May 11, 2017

Project Name: 105-121 Washington Avenue Parking Lot Redevelopment
Planner: Matthew Grooms
Project ID: 2017-024
Address: 105-123 Washington Avenue

RE: Staff Review Comments for Washington Avenue, Parking Lot Redevelopment and Change of Use (2017-024)

DRAWING NO. **C-10**

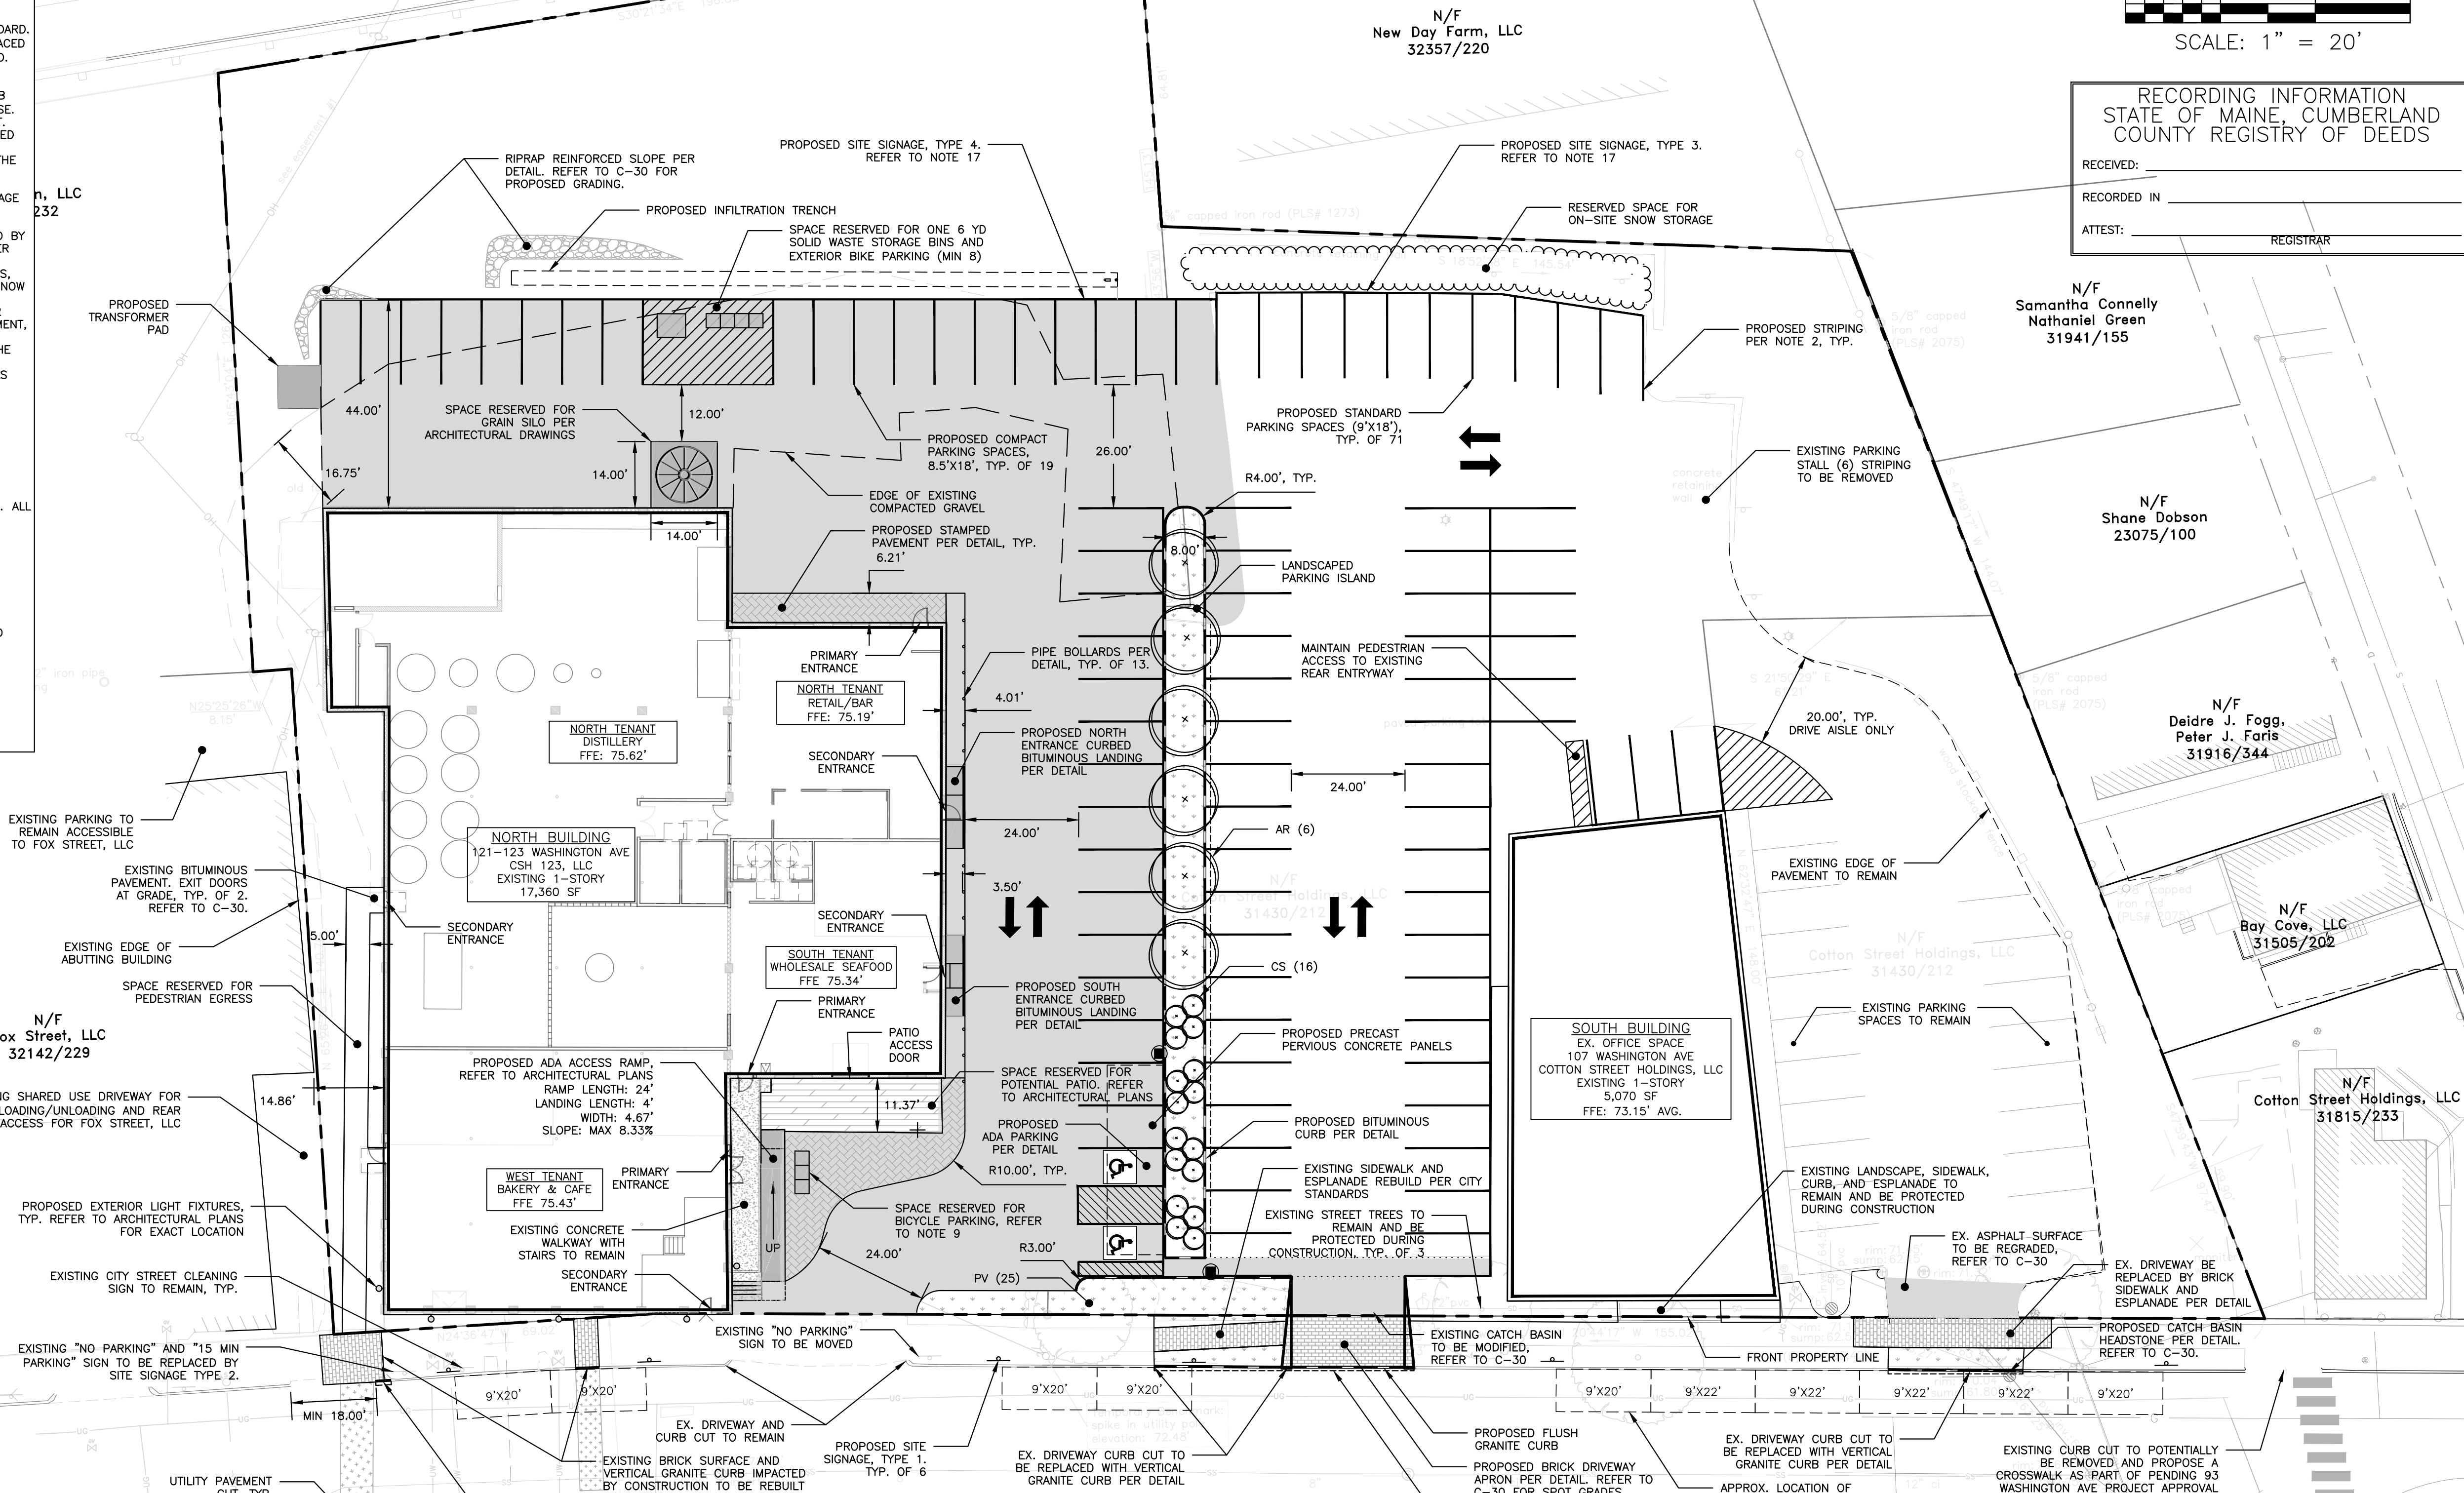
2. The applicant shall provide revised drawings, expanding the proposed sidewalks to 8' feet in width and ensuring that all sections of the sidewalk, including driveway aprons meet the minimum requirements for ADA accessibility.
3. Per Section 13 of the City's Technical Manual, the Applicant shall submit a Boundary Survey that has been Stamped by a Maine Licensed Professional Surveyor.
4. The applicant shall provide finalized easements as described in the applicant's submittal document, 'Summary of Written Easements V2', for shared site access, drainage, parking and landscaping. Easements shall be submitted for review and approval by the Planning Authority, Department of Public Works and Associate Corporation Counsel.

1. The project includes the provision of three driveways on Washington Avenue. City standards permit a maximum of two driveways for a commercial development. The applicant shall either revise the plans to meet City standards or provide supporting information justifying a waiver from the standard. In my professional opinion, the plan should be revised to include two driveways. I would further note that the two northerly driveways do not meet City standards for driveway separation. This further supports elimination of one of the driveways.

2. The site plan depicts a painted area along the south side of the building that I presume is to serve as a pedestrian walkway. I would suggest that a raised sidewalk facility be considered if this is to serve pedestrian access and egress movements to a building entrance.
3. The applicant should provide information regarding details on the northernmost driveway that appears to be partially on the applicant's property. It is unclear to me as to use and ownership of this driveway.
4. I have reviewed the revised site plan as it relates to the Grain Silo and impacts to parking and circulation. Given the location to the rear of the property and limited traffic activity, I find the circulation system to be acceptable and support a design waiver for parking aisle width.

2. Would the applicant consider closing the northernmost curb cut along Washington Avenue? At present, four points of vehicular ingress and egress exist at this location and this curb cut in particular does not appear to serve a purpose.

3. On the site plan, all points of building ingress and egress shall be called out.
4. How will refuse be handled on site? Per Section 14-527(f), the location and size of all -on-site solid waste receptacles, including on-site storage containers for recyclable materials shall be included.

6. The central parking lot landscaping aisle appears to be roughly 7.15 feet in width, whereas under Section 14-526 (b) Environmental Quality Standards, a landscaping island measuring 8 feet in width not including curbs is required.

12. How many spaces will be made available for bicycle parking?
13. Per discussions with the City Arborist, the center island shall include 3 additional parking lot trees, and all trees should be more uniformly distributed throughout the island as opposed to being clustered towards the rear of the site.
